Late Items – Planning & Development Committee				 Ribble Valley Borough Council www.ribblevalley.gov.uk	
Meeting Date: 23 JULY 2026					
Briefing version		Issue Date:			
Committee Version		Y	Issue Date:		23/7/26
Application Ref:		3/2025/0801	Land to east of Salesbury View Wilpshire		REC: Defer & Delegate
Since the publication of the Committee Agenda further information has been received as follows:-					
LCC Education has requested a contribution towards permanent expansion of one of the nearby local schools for 13 primary places at a cost of £20,450 per place. This equates to £265,850.00 and would need to be secured in the S106 Agreement.					
Independent Technical Planning Review prepared by Wellbeing Designs on behalf of Wilpshire Parish Council					
This report is published on the Council's website:- 25_0801 Independent Technical Planning Review from WPC 22jul26.pdf					
A summary of the review is as follows:-

Highways and Transport Review prepared by CTS Traffic & Transportation Ltd on behalf of a local resident

PROJECT / CLIENT Salsbury View, Wilshire for Persimmon Homes		PROJECT NO. NB13203	
DRAWING TITLE Proposed Site Sections		DRAWING NO. 112	
PROJECT LEADER KD	DRAWN BY KW	CHECKED BY IDP	DRAWING REVISION P8
SCALE 1200 @ A0		DATE August 2025

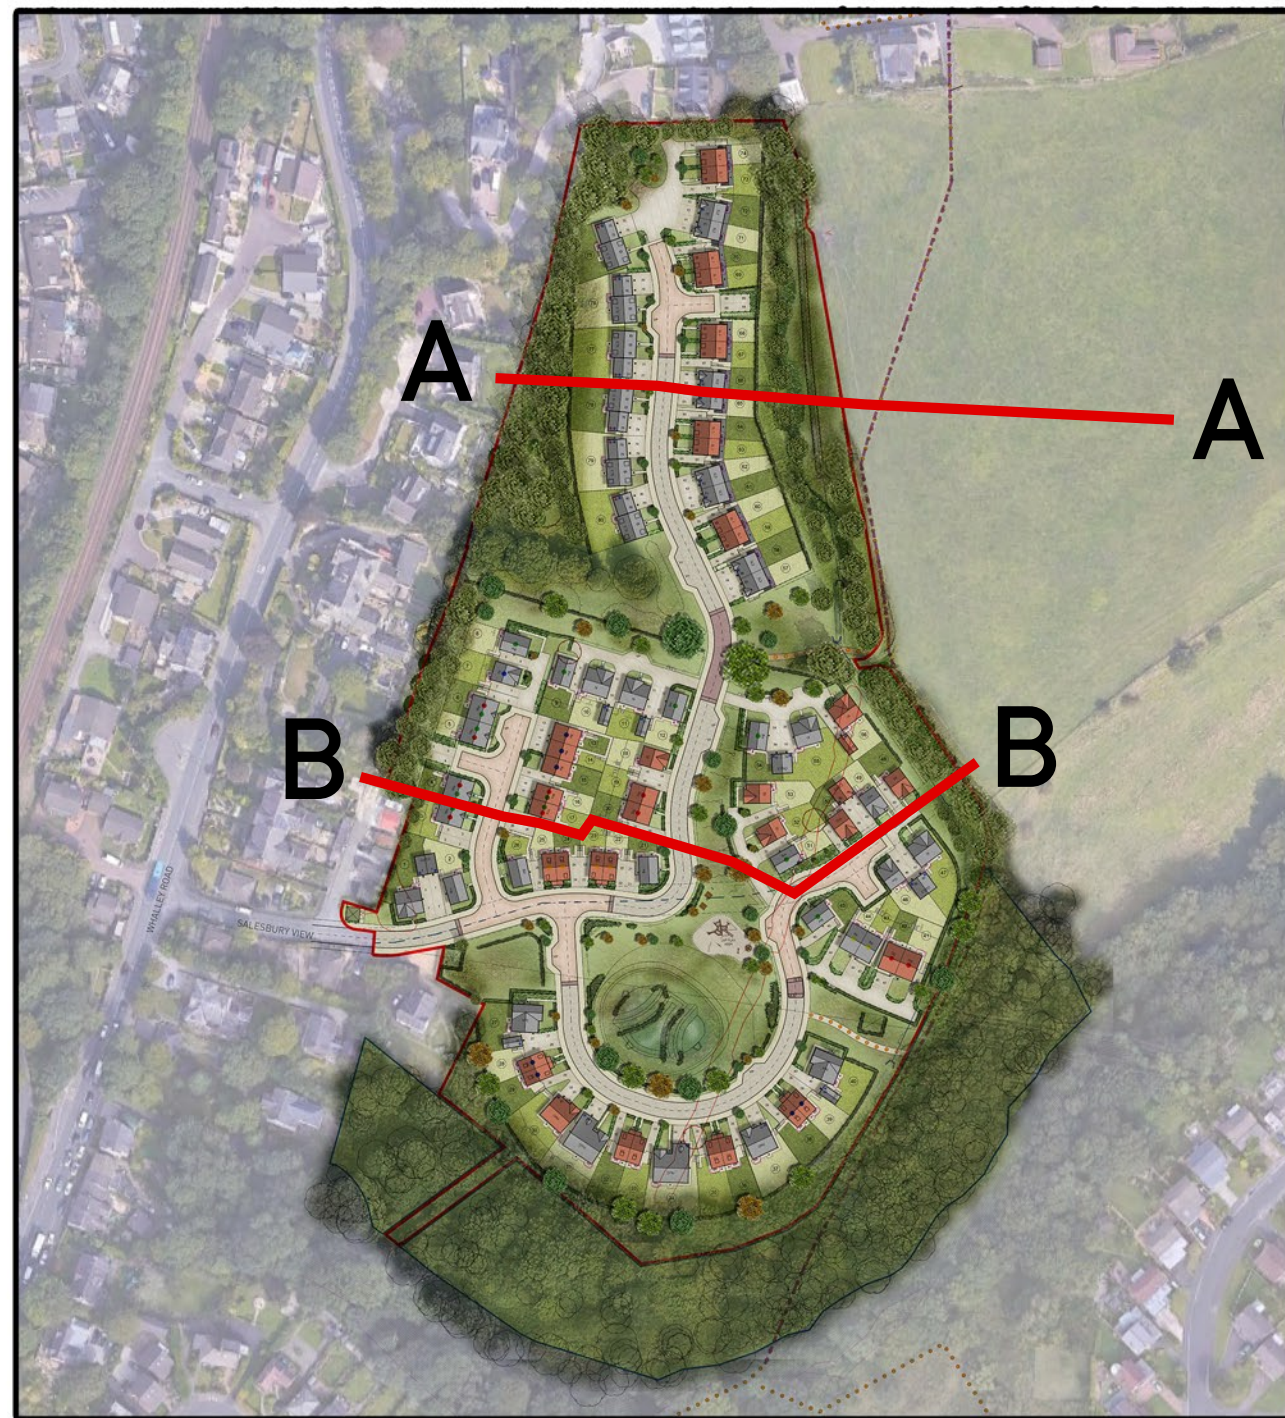
- Extensive engineering works, including retaining walls, remain central to the development.
- Amendments do not eliminate the need for landform manipulation or reduce visual impacts.

- Multiple engineering interventions collectively alter the natural landform.
- The proposal appears imposed on landscape rather than responding to it.
- Significant level changes and steep access roads remain key physical constraints.

- Reliance on retaining structures and land re-profiling remains necessary for development.
- Some boundary areas lack sufficient space for effective landscaping.

- Higher boundary retaining structures may remain visually prominent initially.
- Relationships between structures, levels, and boundaries remain largely unchanged.

- In terms of the retaining structures these would now be set into the hillside and greened over so they would not be as visible (point 19).
 - Plots have been completely reorientated and the housetypes changed which individually address the Inspectors point which must improve the overall cumulative impact (Point 20)
